Re: ACCESSIBILITY CAPABILITY STATEMENT AT DA STAGE – Rev B

Project: Sydney Opera House – White Box (TIDE) – Bennelong Point, Sydney

The purpose of this submission is to advise that we have undertaken a preliminary disability access design assessment of the proposed development, known as the Tours Immersive Digital Experience (TIDE) within a White Box room, as identified in architectural drawings listed below in Table 1. A preliminary site inspection was also conducted by this office on the 27 August 2019.

Location	Drawing No	Sheet	Rev
SF GF	49-FB-SC029	DA120	A

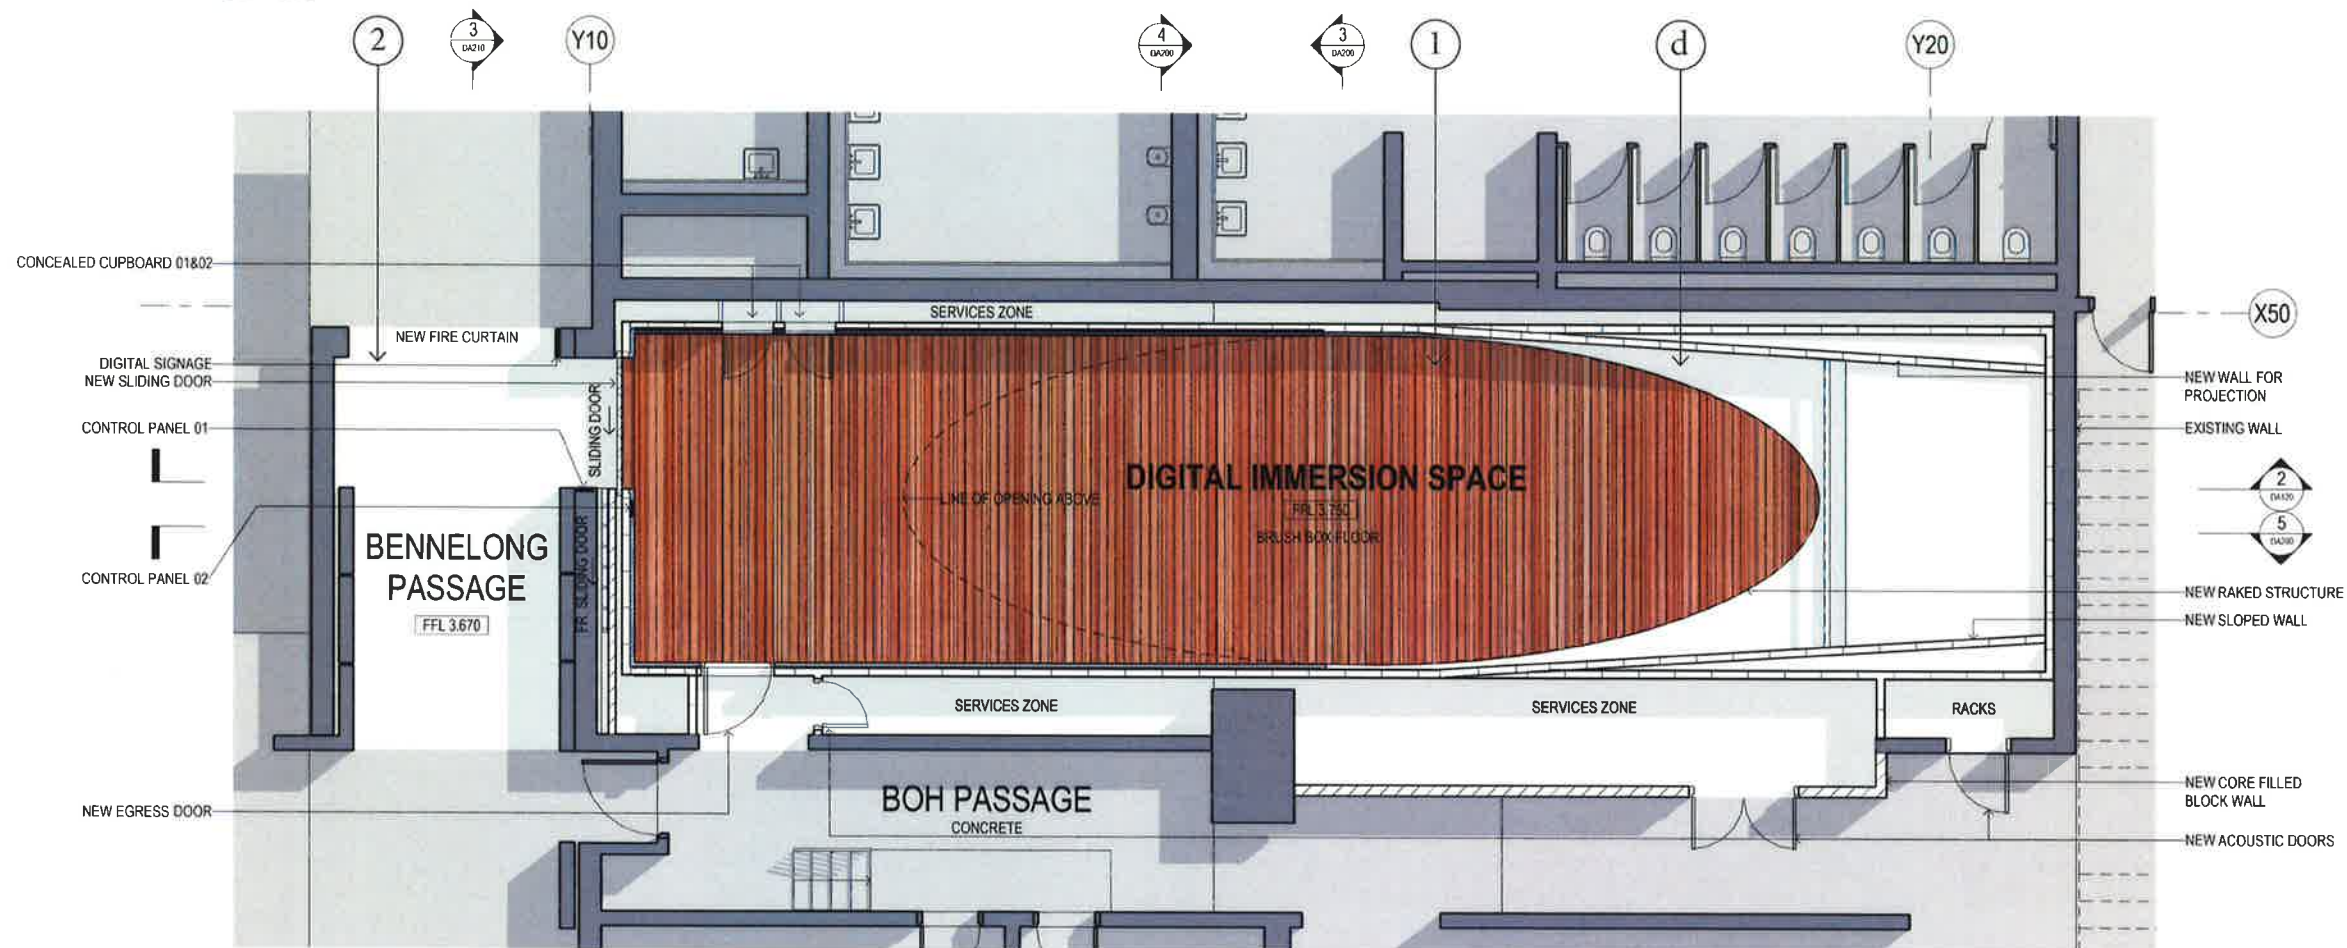
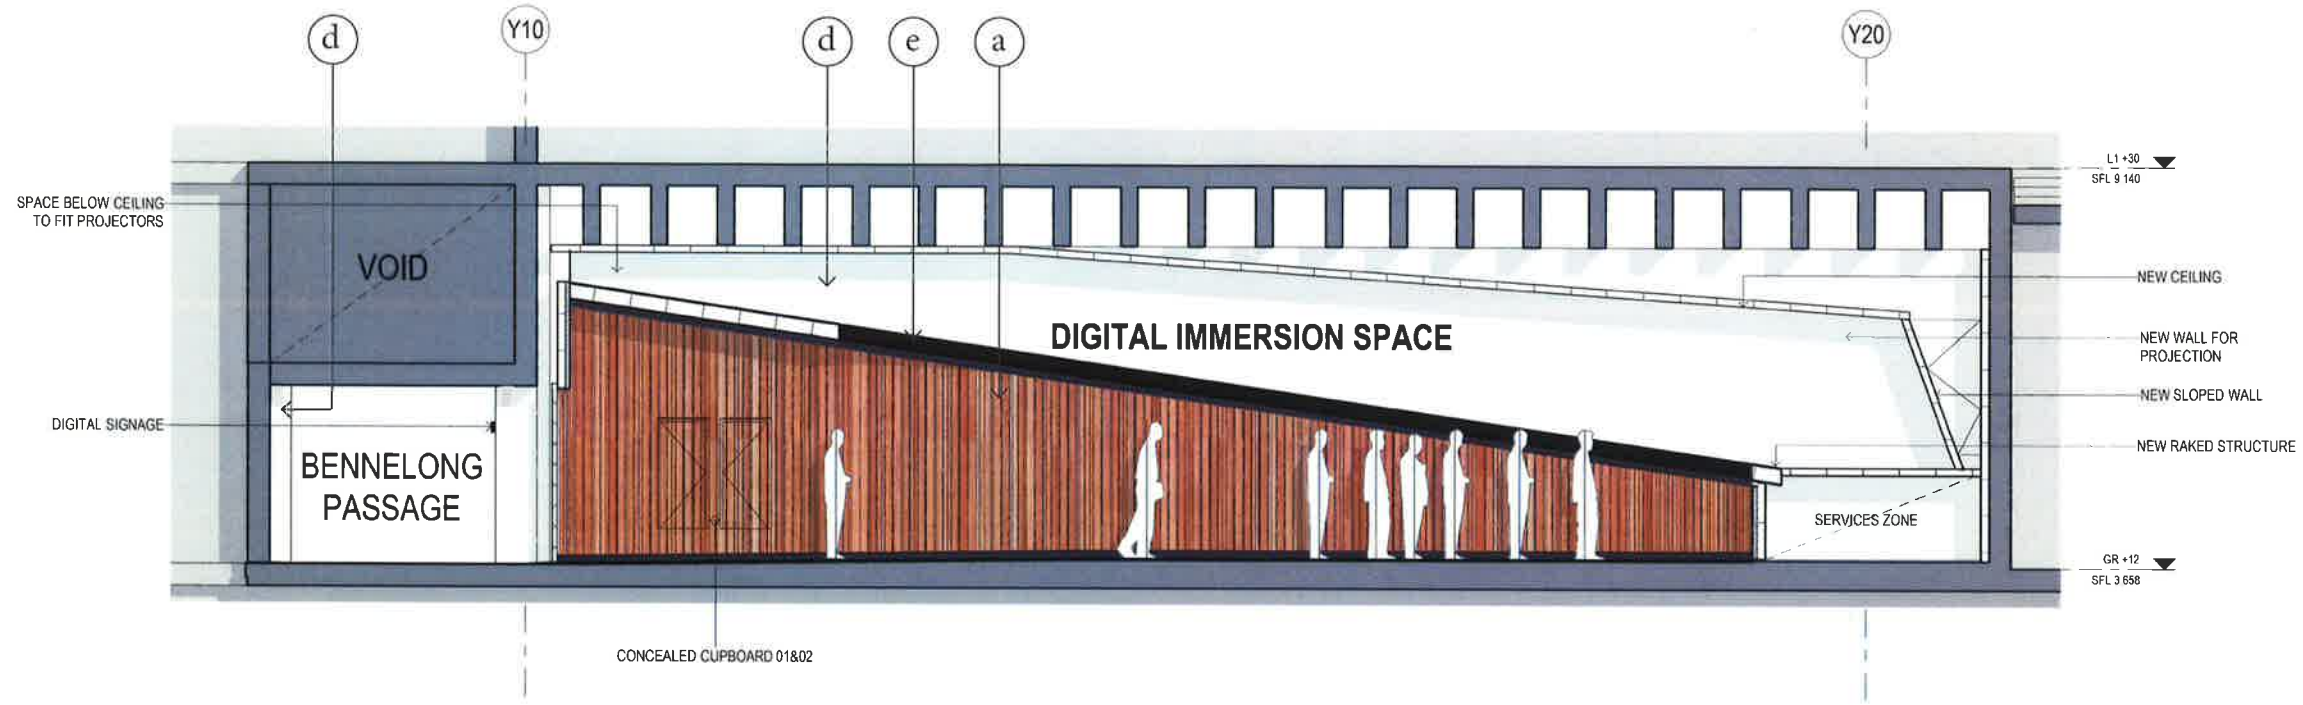
- b) The TIDE space is an open plan room (approx. 65m²) with generous circulation area that can achieve compliance for continuous paths of travel, at least 1000mm min. clear width path of travel between fixtures and furniture (when no turning required) and at least 1540mm W x 2070mm L clear area at a corridor end formed between fixtures and furniture (when 180-degree wheelchair turn required) in accordance with AS1428.1:2009. The proposed timber floor-board finish will be a level and even surface which is deemed suitably traversable by people with disability. Compliance is readily achievable.

- c) The new works services zones surrounding the TIDE room are restricted for the customised services to support the digital experience can be supported as a non-accessible area, under a Part D3.4 exemption due to the particular nature and use that may pose a health or safety risk to people with disability.

While there are currently 2 x new egress doors indicated from the TIDE room, it is understood from the BCA consultant that while both egress doors are on a required path of travel, neither door is required by BCA Clause E4.5 to be provided with an Exit sign, therefore accessible egress signage, compliant with Part D3.6 is not required.

3 DA SECTION BENNELONG PASSAGE - PROPOSED
1:50

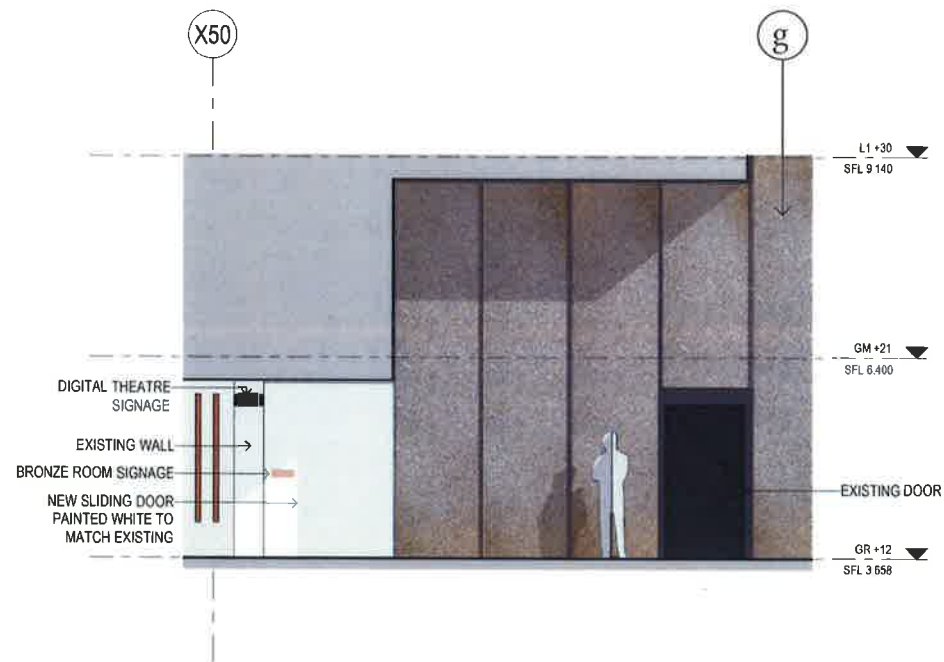
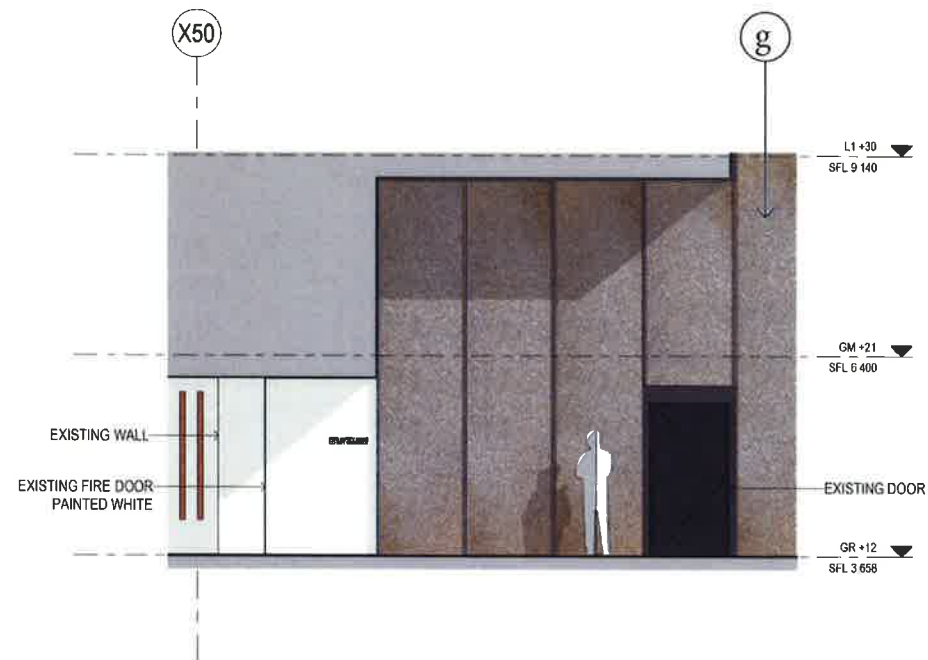
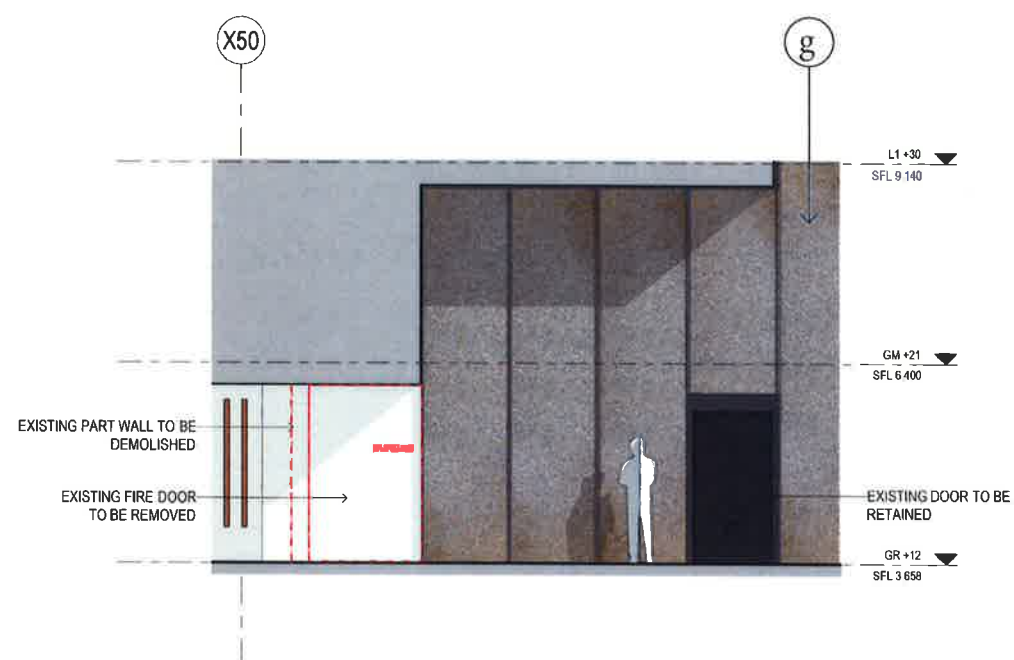
- a) Door Clearance/Circulation: The proposed door exceeds 850mm min. clear width opening and there is adequate clear space on either side of door for approach/circulation area. As a power operated sliding door, no latch side door clearance is required. Compliance is readily achievable.
- b) Door Controls: The manual door controls to activate the door opening ie. security swipe and control buttons are required to be in an accessible location at least 500mm min. distance from an internal corner and/or obstruction and between 900-1200mm above FFL. Compliance is achievable and the final door control type and location will be determined during design development/detail stage.
- c) Luminance Contrast: The door is required to achieve 30% min. luminance contrast to the surrounding surface under AS1428.1:2009,

Externally the door is proposed to be painted white. While this provides sufficient luminance contrast to the existing granite wall panels, it is the same colour as the existing adjacent wall and a departure from AS1428.1. Internally the door is proposed to be brush-box veneer finish, similar to the brush-box wall lining. Internal compliance is achievable eg. by including a 50mm min. width luminance contrasting frame around the door, and this will be considered/addressed during design development/detail stage in conjunction with the design team. While internal DtS compliance is preferred for future-proofing, given

the unique function/use of the space and heritage nature of the building a performance-based approach is also supportable for both internal and external sides based on the secured/managed use of the door by SOH staff only.
